**Shoalhaven Hydro Expansion Project – SSI-10033**

I am writing in reply to your request for comment from the Environment Protection Authority (EPA) regarding the Shoalhaven Hydro Expansion Project (SSI-10033) Environmental Impact Statement (EIS).

### EPA INFORMATION REQUIREMENTS FOLLOWING REVIEW OF ENVIRONMENTAL IMPACT STATEMENT

PERMANENT SPOIL AREA CONCEPT - OPTION 2

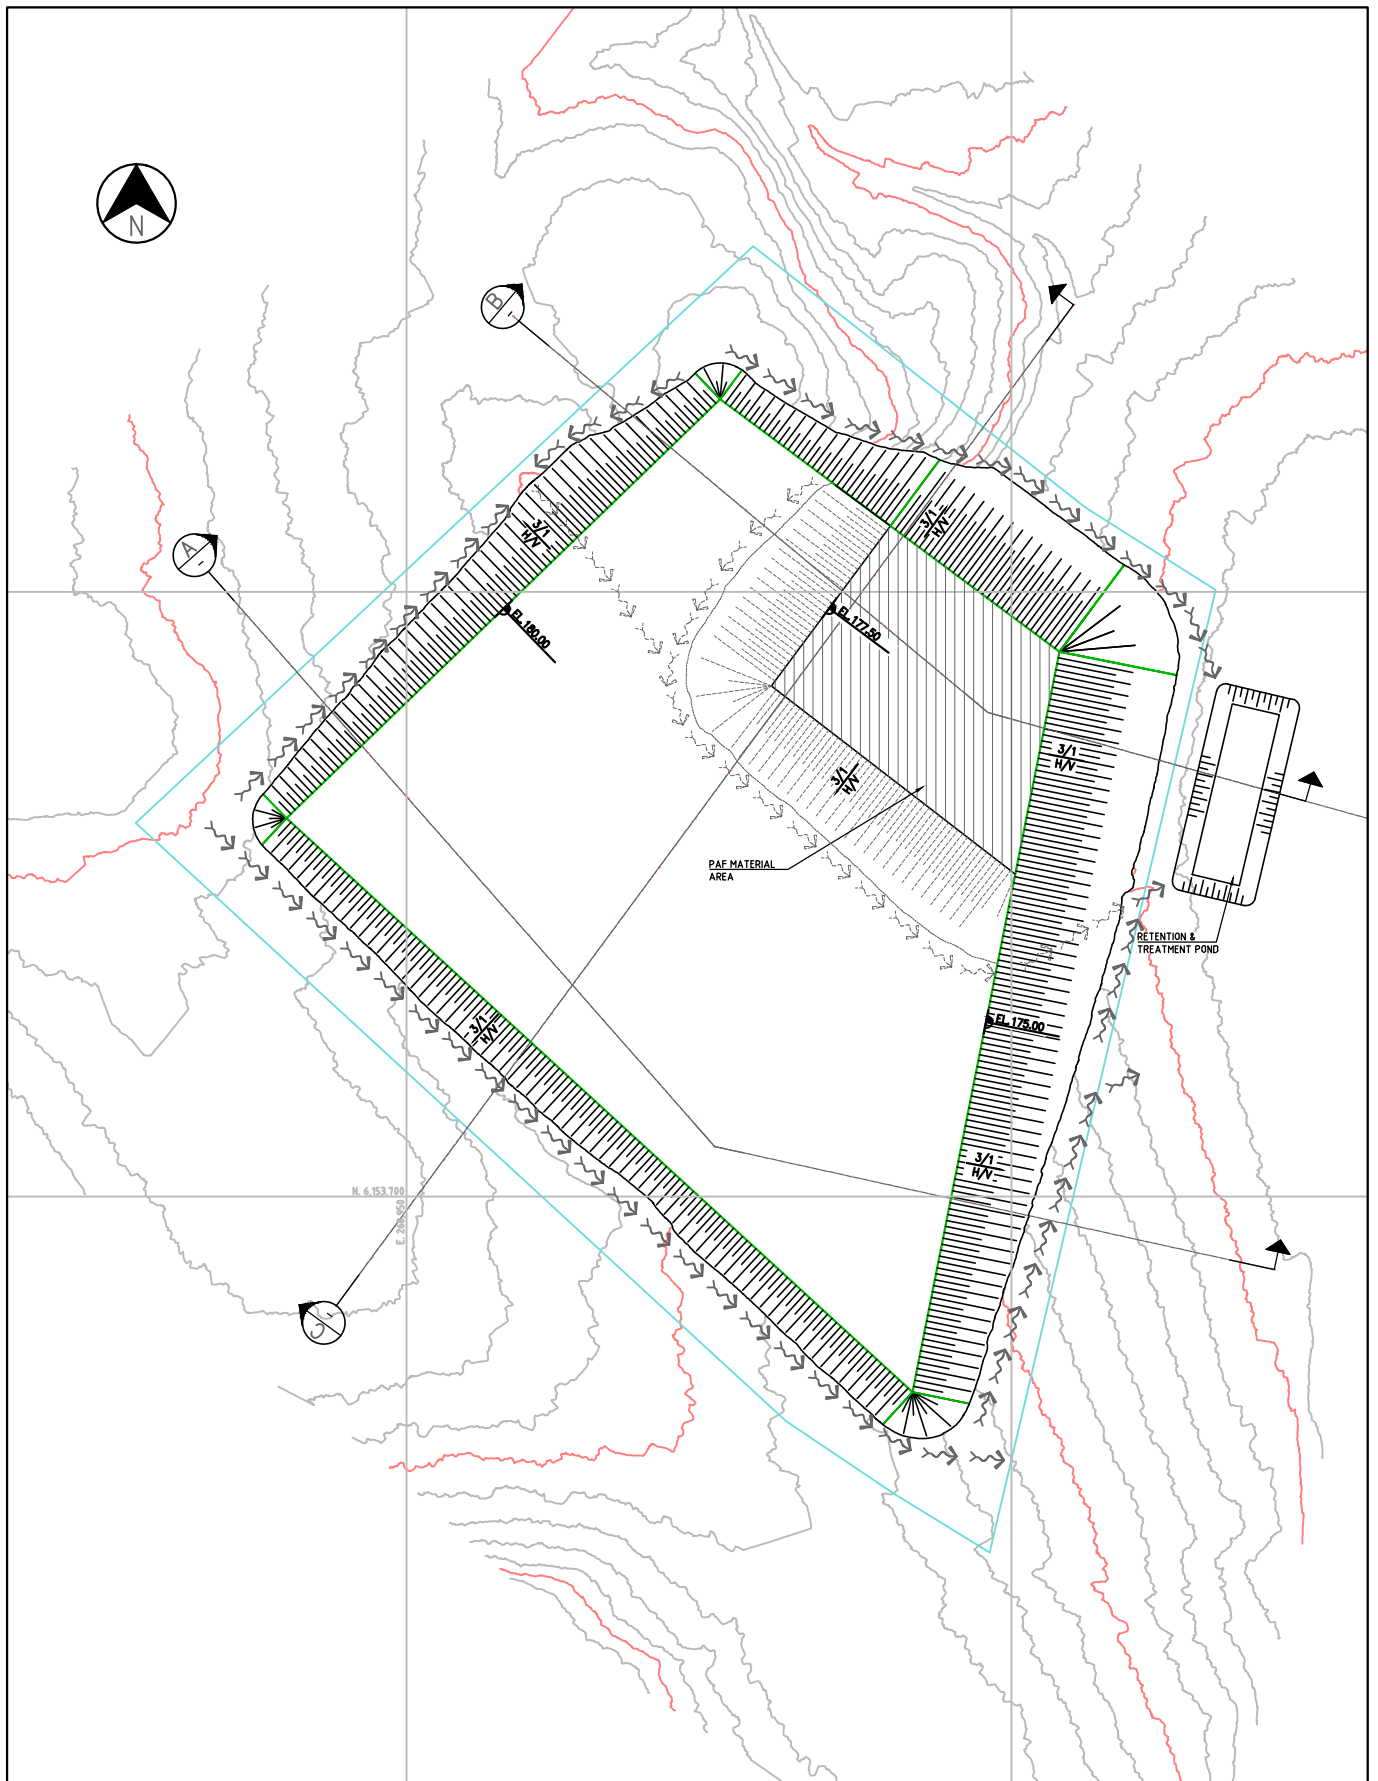
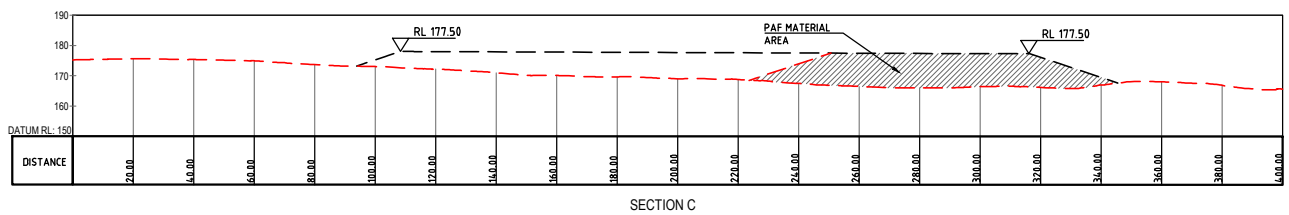
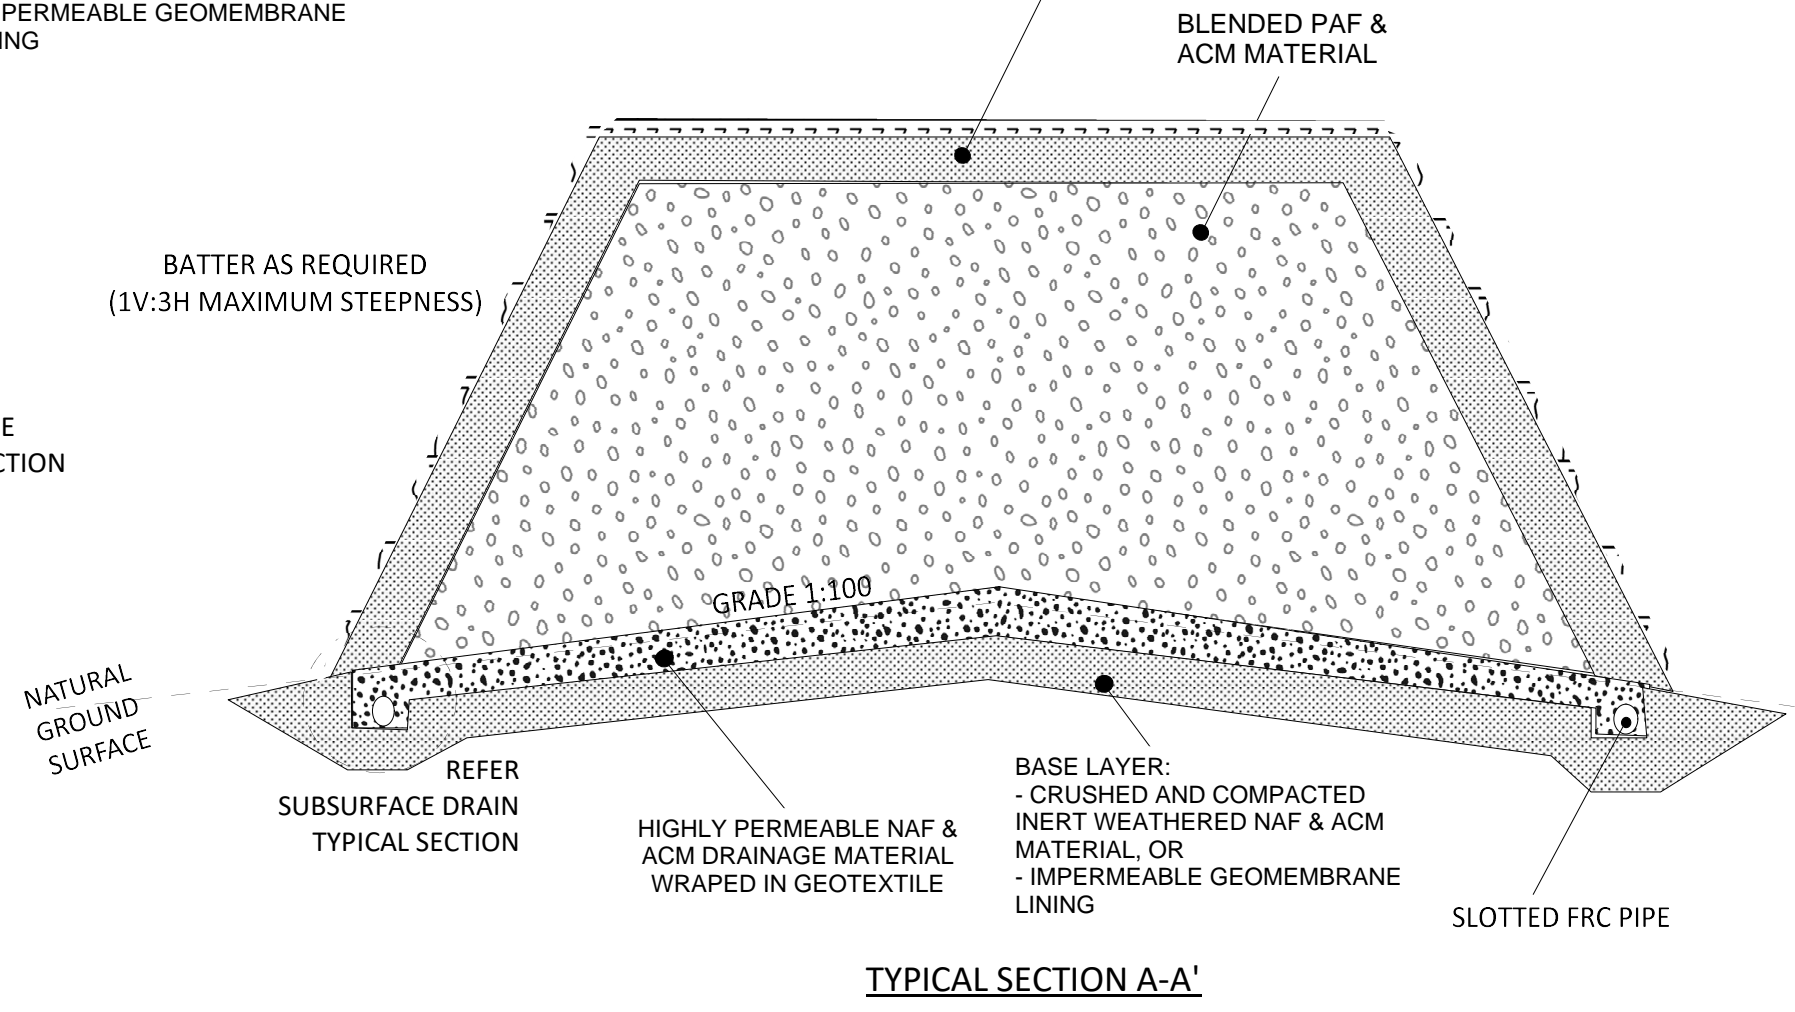
#### **The spoil management approach is unclear**

The EIS has not demonstrated that the proposed methods to manage spoil will prevent the generation of leachate which could contain pollutants at levels that cause harm.

Methods to manage the PAF spoil in Appendix I (Surface Water Quality, Hydrology and Geomorphology) are inconsistent with Appendix K (Spoil Management Strategy).

The existing characterisation of the spoil and its leachate is unclear and its temporary and permanent management is insufficient to determine if the proposed lining and encapsulation measures in the spoil management strategy is sufficient to protect groundwaters at the proposed spoil emplacement site.

A retention pond (‘Sediment Basin 5’) is proposed to capture runoff and leachate from the spoil emplacement area. The EIS has not characterised the expected discharge quality from the spoil emplacement area as there has been no appropriate geochemical/leachability tests to characterise the excavated material. Furthermore, as the emplacement method has not been confirmed, the expected water quality outcomes are unclear.

The expected volume of leachate generated from the emplacement area is unclear. It is also unclear if the emplacement sediment basin / retention pond has been appropriately sized to contain contaminated stormwater/leachate during testing and treatment.

- *Undertake geochemical/leachability tests for the full stratigraphy of the site to develop suitable procedures for handling, storing, treating, and disposing of excavated material and inform the retention ponds discharge impact assessment (refer to Section 4 below)*

- *identify the testing frequency for excavated material prior to emplacement*
- *consider and assess any potential risks and impact to receiving waters for all pollutants at non-trivial levels from the rock/spoil emplacements, including leachate, migration of sediment and surface water runoff. If any potential impacts are identified appropriate management and mitigation measures should be proposed.*
